**RE: Panda Express – Gibson
2040 Gibson Blvd SE
Grading and Drainage Plan
Engineer's Stamp Date: 06/10/24
Hydrology File: M15D021F**

RE: Panda Express – Gibson
2040 Gibson Blvd SE
Conceptual Grading and Drainage Plan
Engineer's Stamp Date: 09/12/23
Hydrology File: M15D021F

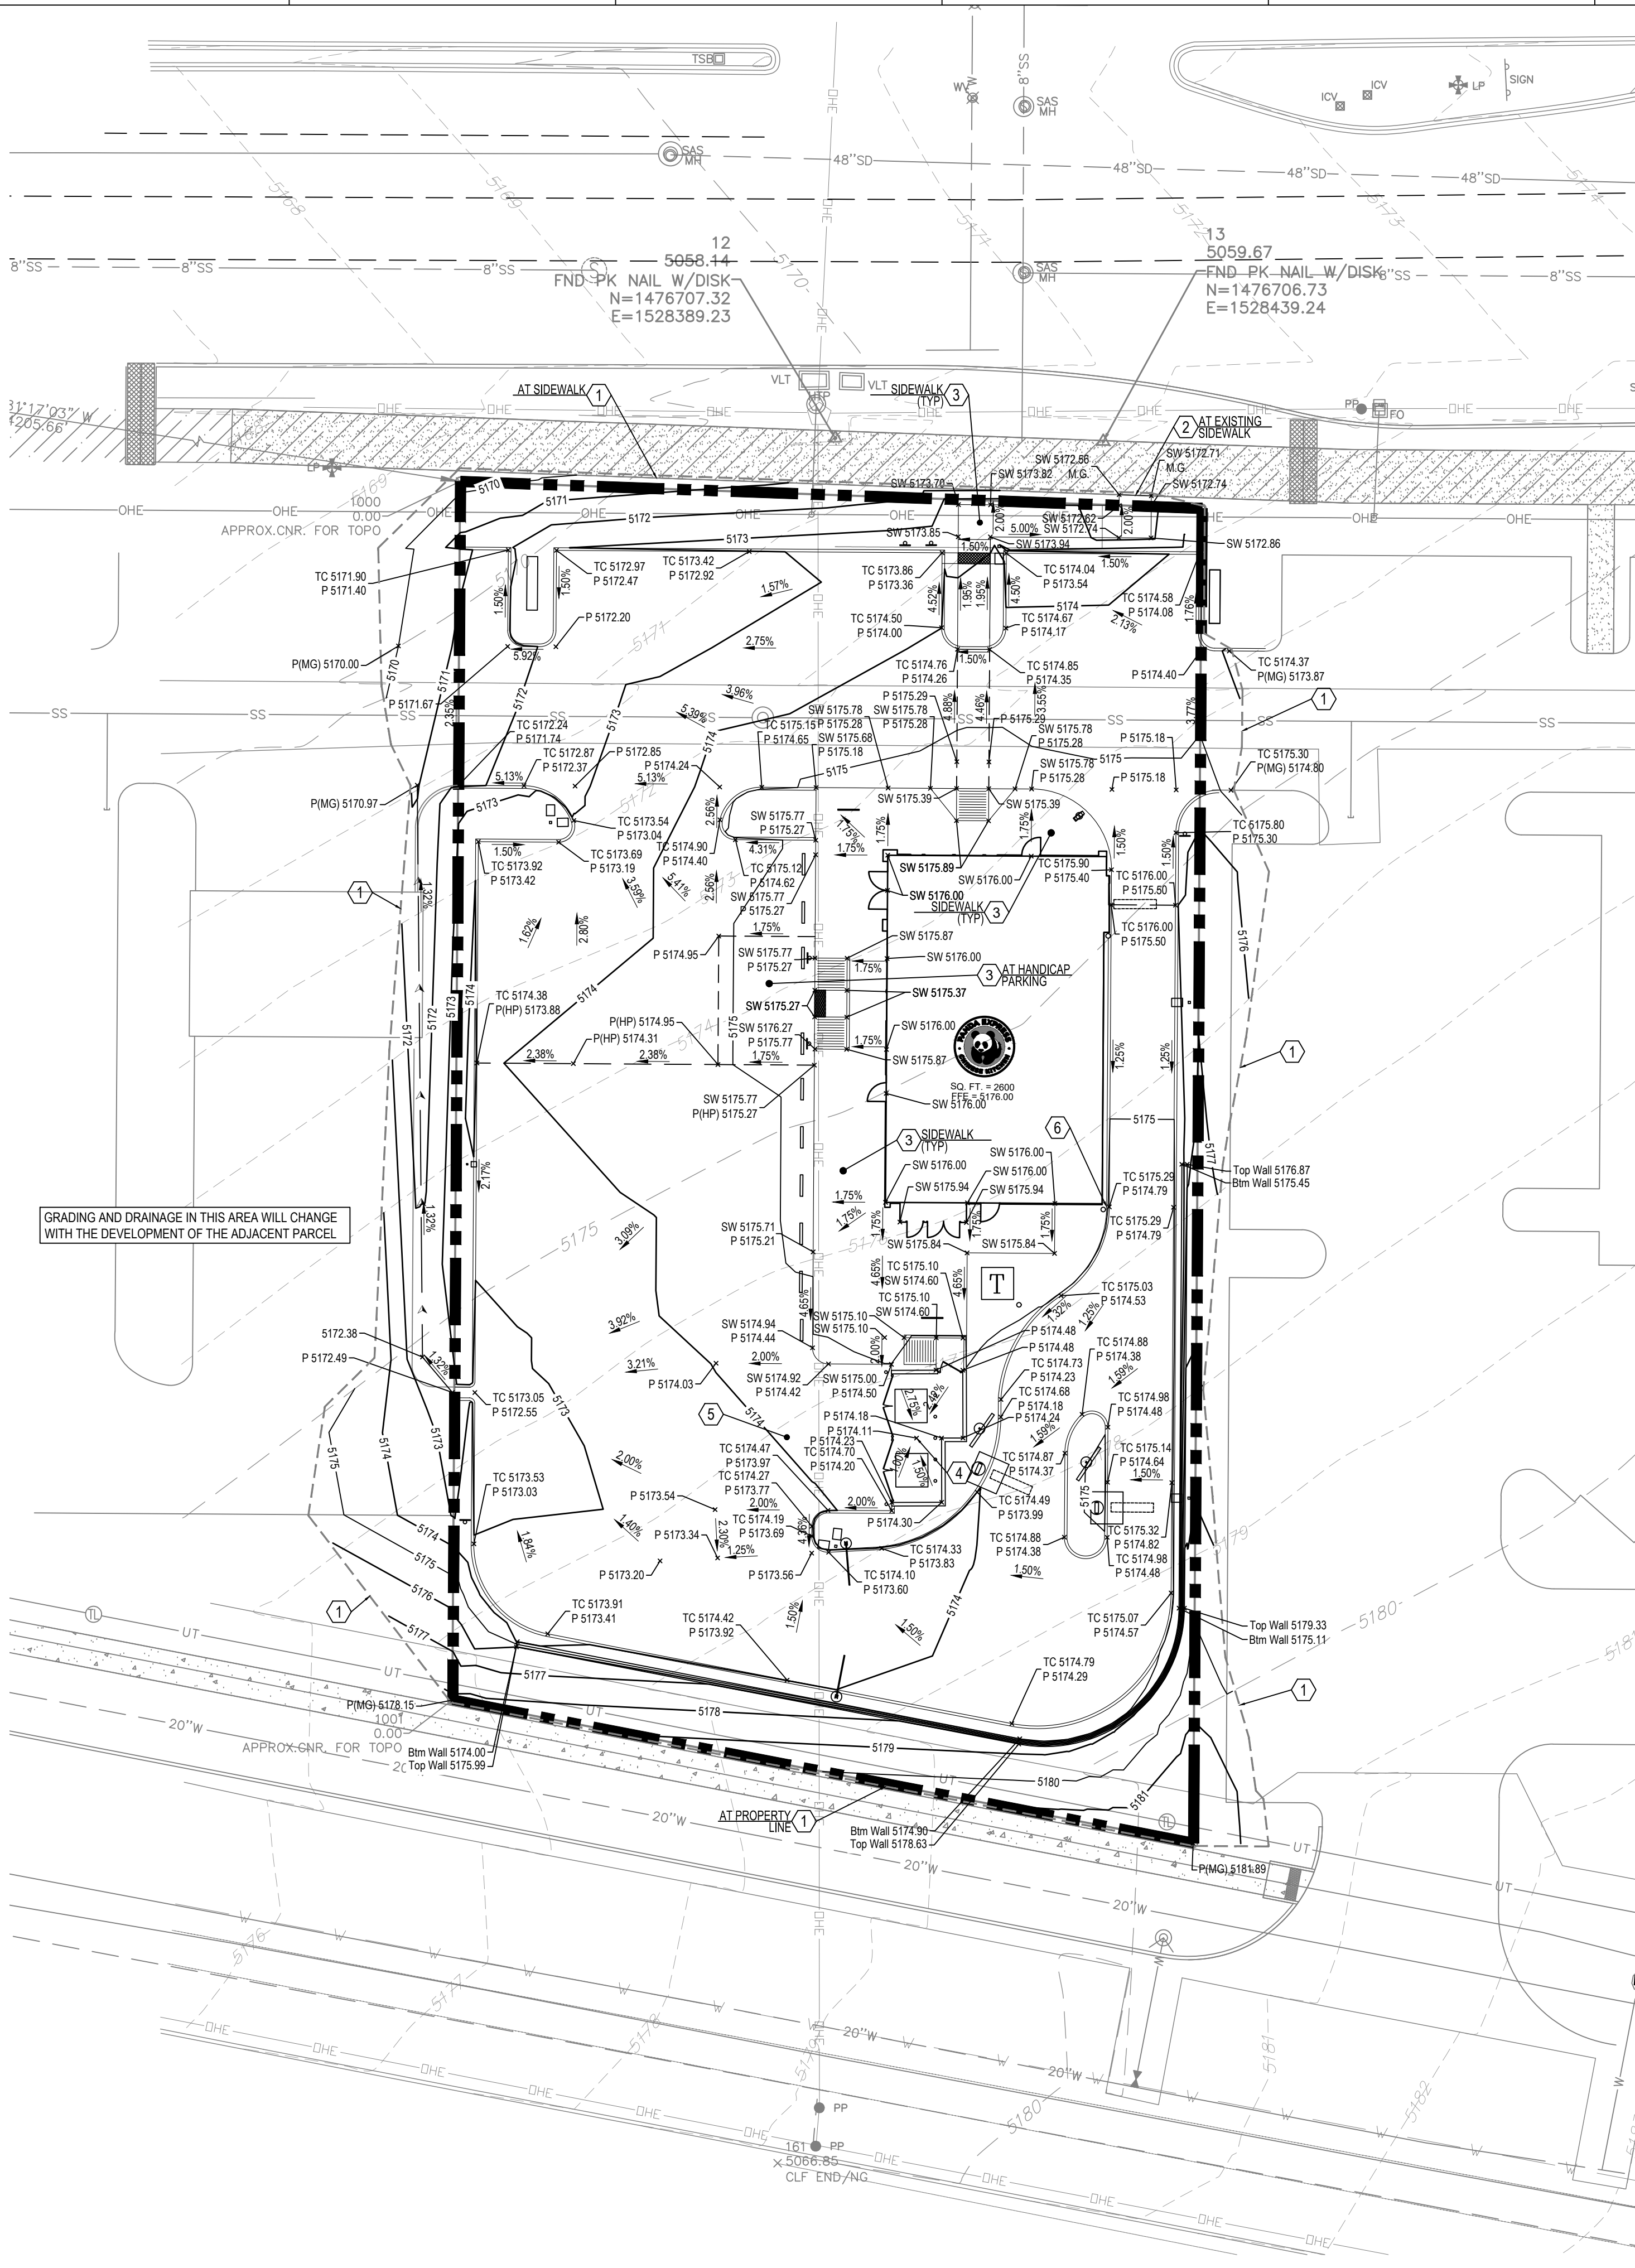
1. Per the DPM, the following must be on the Grading Plan. Please note the Grading Plan must be a stand-alone construction document.

- a. Please provide the Benchmark information (location, description and elevation) for the survey contour information provided.

- b. Please provide a legal Description of the property.

2. Please use the procedure for 40 acre and smaller basins as outlined in Development Process Manual (DPM) Article 6-2(a). Please provide both the existing conditions and proposed conditions for the 100 year-6 hour storm event. This site is part of the Lovelace Heights Drainage Master Plan (attached). Please reference this under the Proposed Conditions. This site has two drainage areas which sheet drains through the adjacent property to a sidewalk culvert.

3. Please follow the DPM Article 6-12 Stormwater Quality and Low-Impact Development for the sizing calculations. To calculate the required SWQV, multiply the impervious area (Square feet) draining to the BMP by 0.42 inches for new development sites divided by

12 to get the required volume in cubic feet. The calculations of both the required and the provided volume of each BMP must be shown on the Grading and Drainage Plan. Each BMP should be labeled on the Grading and Drainage Plan with the required SWQV and associated water surface elevation and the 100-year water surface elevation. Landscaping of surface BMPs is also required to be noted on the Grading and Drainage Plan.

6. For trash enclosures serving food service developments, trash enclosures must demonstrate control of liquids from dumpster areas per DPM by containing runoff from the dumpster area, preventing outside drainage from entering the dumpster area, and discharging to the sanitary sewer. Please show an inlet in the middle and label. "Inlet to be connected to the sanitary sewer. See Utility Plan."

Response 1a: Benchmark information provided, see BM 24-L16 on Grading and Drainage Plan C05.0

Response 1b: See Legal Description on Grading and Drainage Plan C05.0

Response 2: See Table of existing and proposed conditions on Grading and Drainage Plan C05.0

Response 3: See stormwater quality on Grading and Drainage Plan C05.0, see also attached waiver.

Response 6: Inlet and label added, see keynote 4 on Grading and Drainage Plan C05.0
